FINAL DRAINAGE REPORT
for
KETTLE CREEK ESTATES FILING NO. 2

November 30, 2023

JPS Project No. 112303
PCD File No.: MS ___

VR246

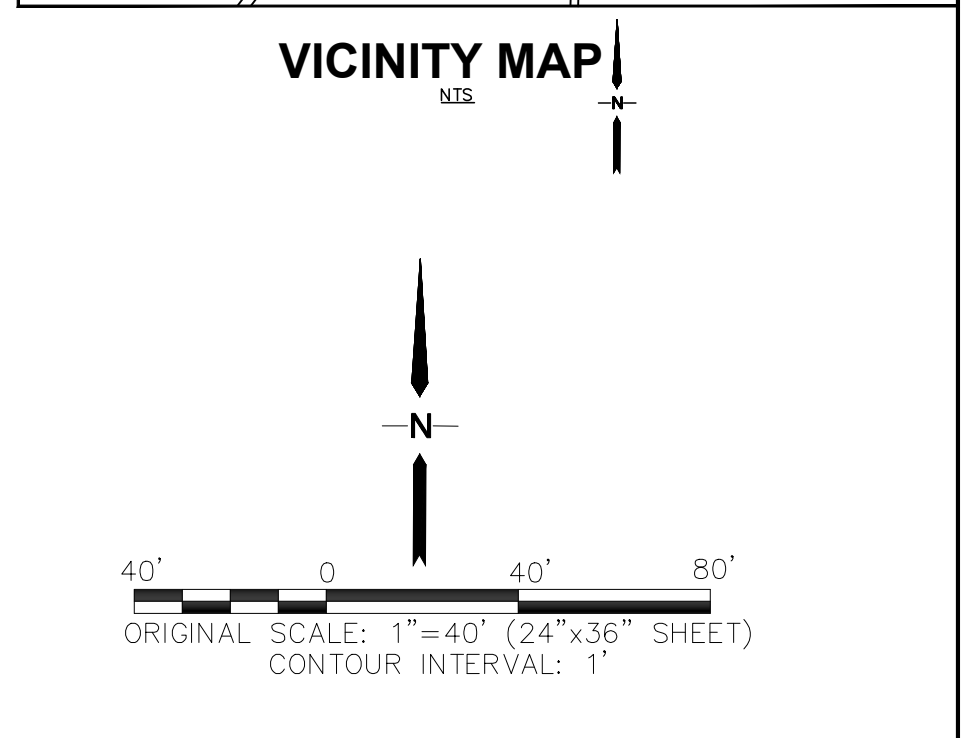
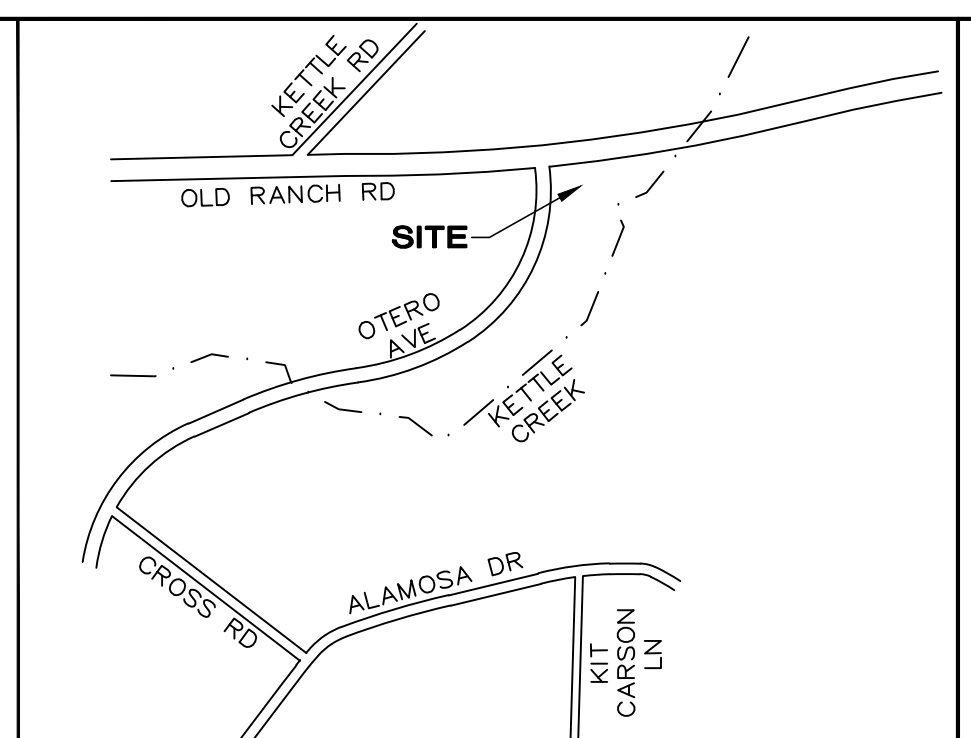
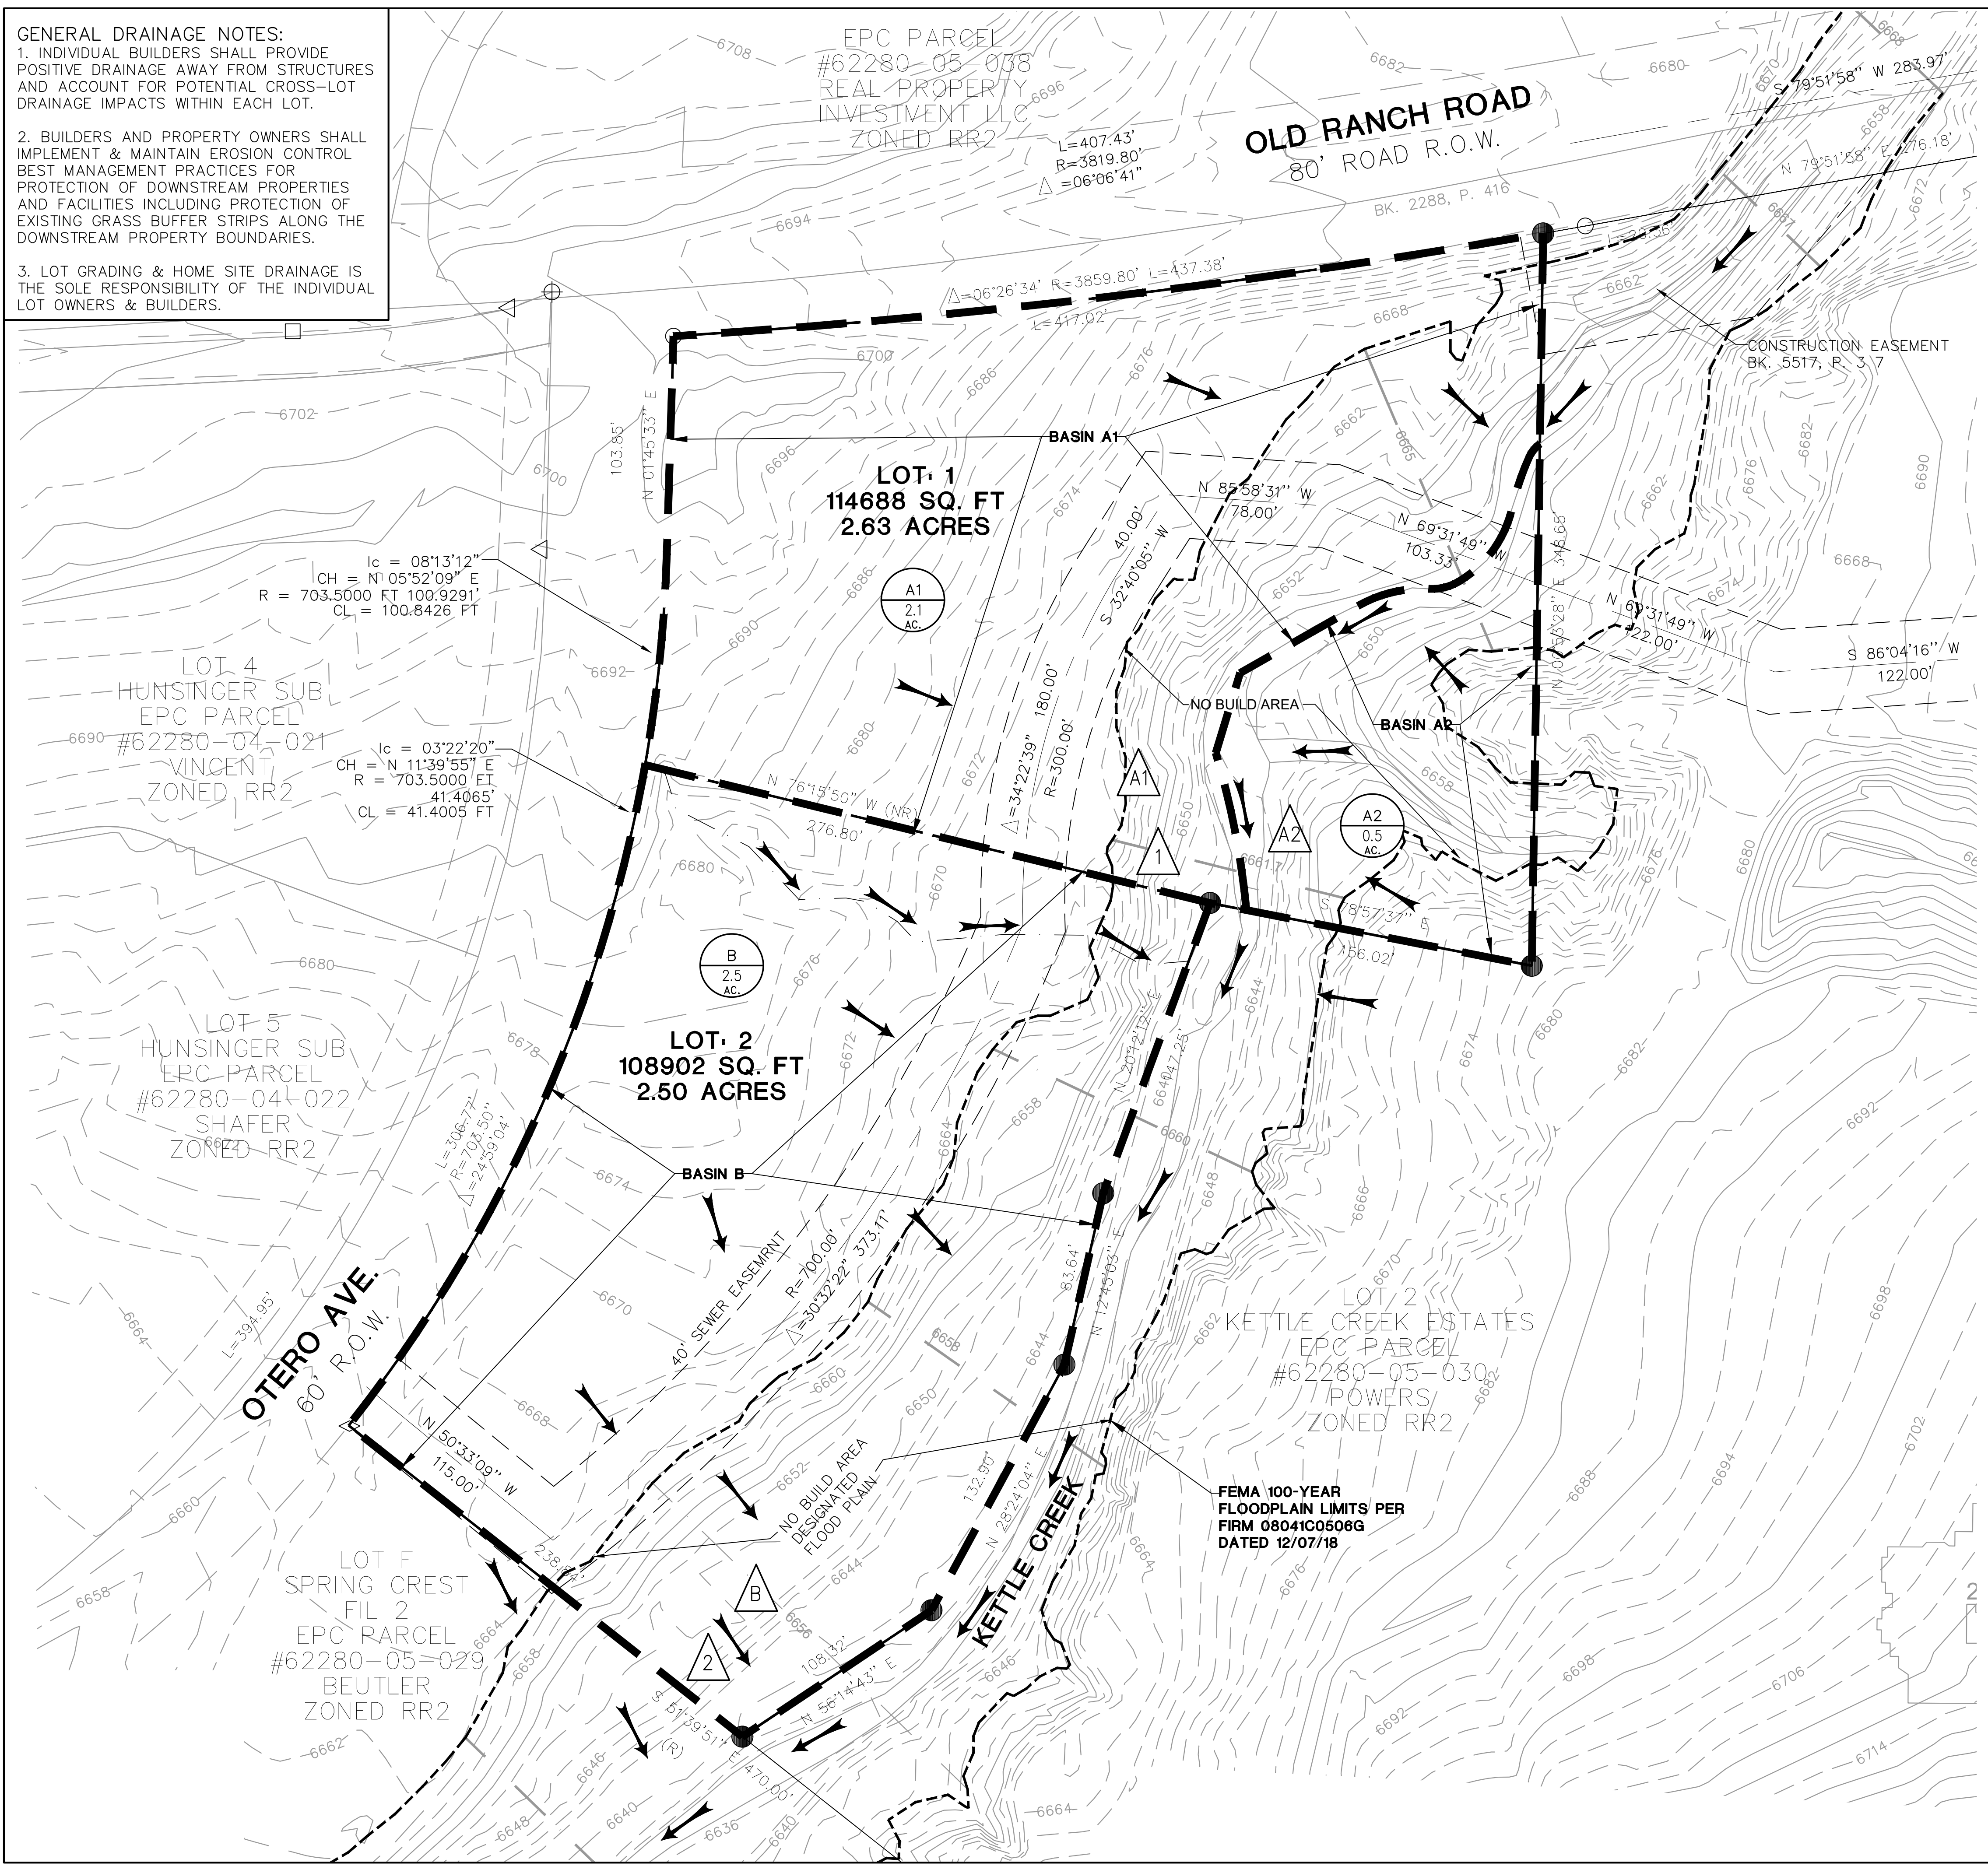
Note: Additional comment will be provided to the drainage report and plat on 7/22 concerning a setback line or no build line along the floodplain due to scour and erosion. Please contact the review engineer.

Explain what improvements are necessary from the developer for the channel

Discuss condition and stability of the floodplain channel along the property boundary. Discuss if the channel needs any improvements or if armoring is necessary.
